RE: *Hale Sand Pit*
PCD File No. AL1829
Site Development Plan and Special Use Permit Resubmittals

Thank you for the comments on January 4, 2019 for the above-mentioned project. In an effort to address your comments concisely and simplify your review of the Hale Sand Pit, we have summarized your comments and our responses below.

Hale Sand Pit - Haul Route Map

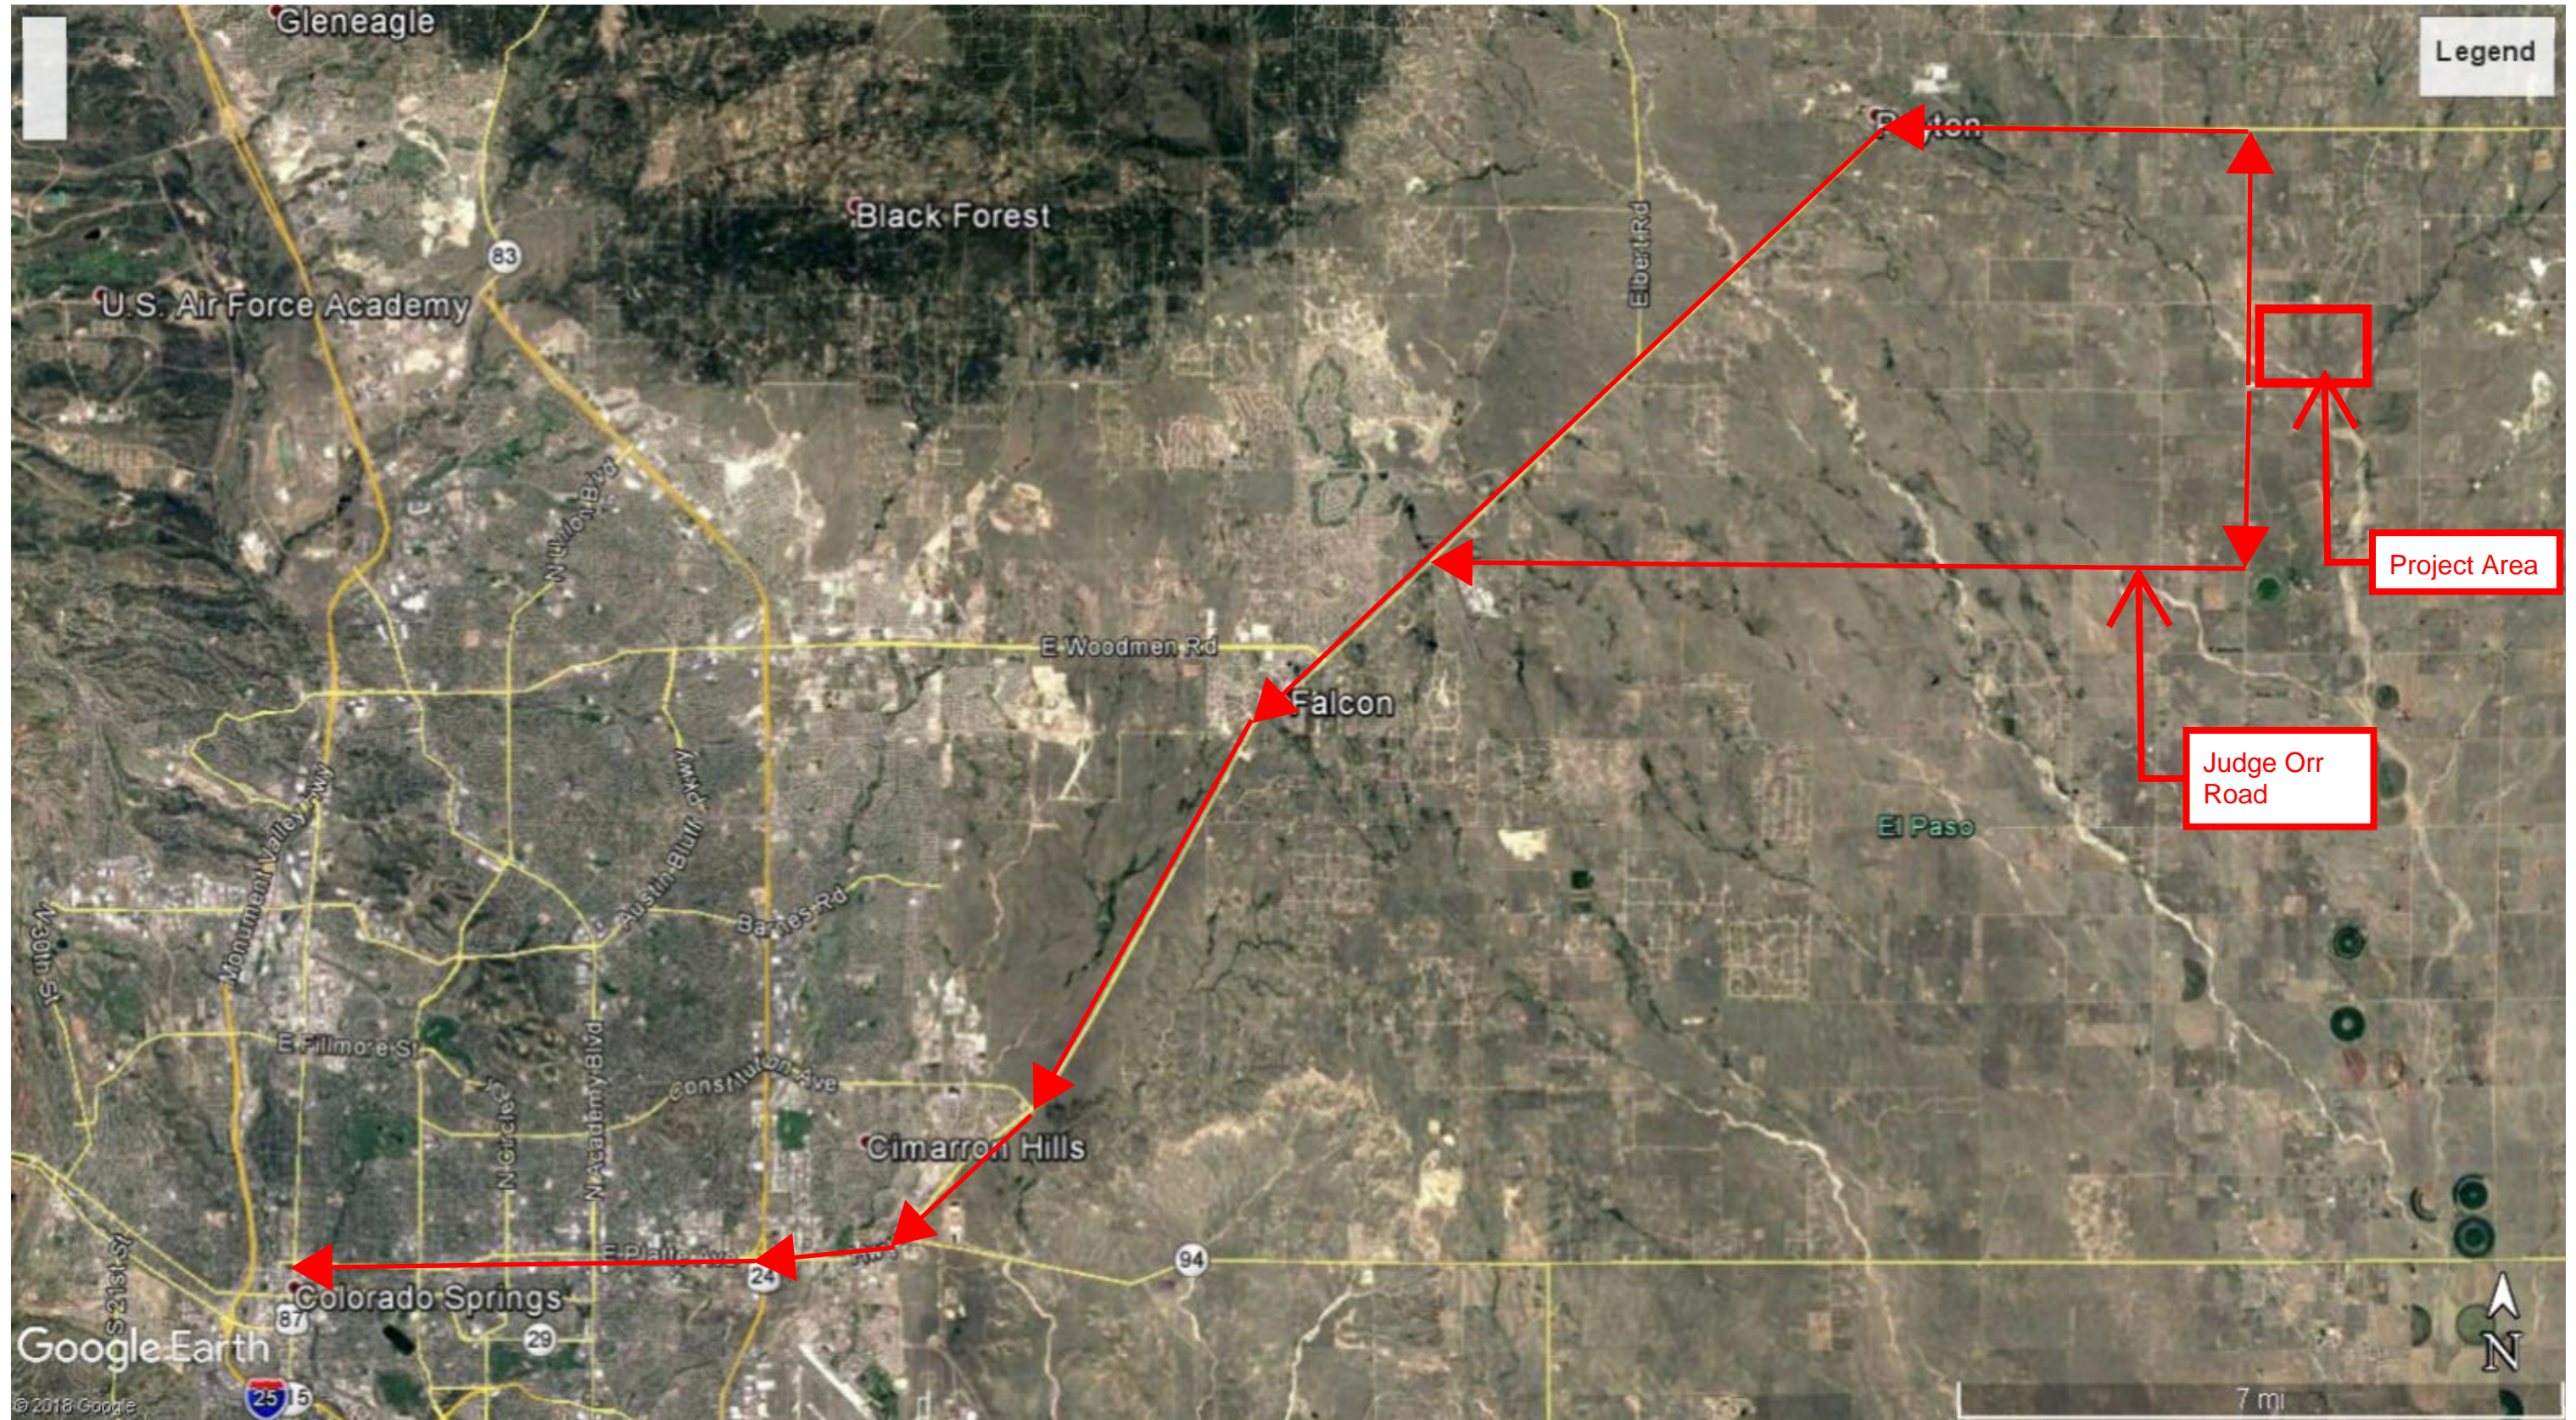
1. Please include additional information including where the trucks will go after they enter highway.
 - *Response: The haul route map was zoomed out to show the trucks entering Colorado Springs from Highway 24 for the Special Use Permit resubmittal.*
2. What is the final destination(s)?
 - *Response: The haul route map was zoomed out to show the trucks entering Colorado Springs as their final destination. Text was also added to the haul route map indicating that the trucks will be going to a variety of location within Colorado Springs and the greater area based on need.*
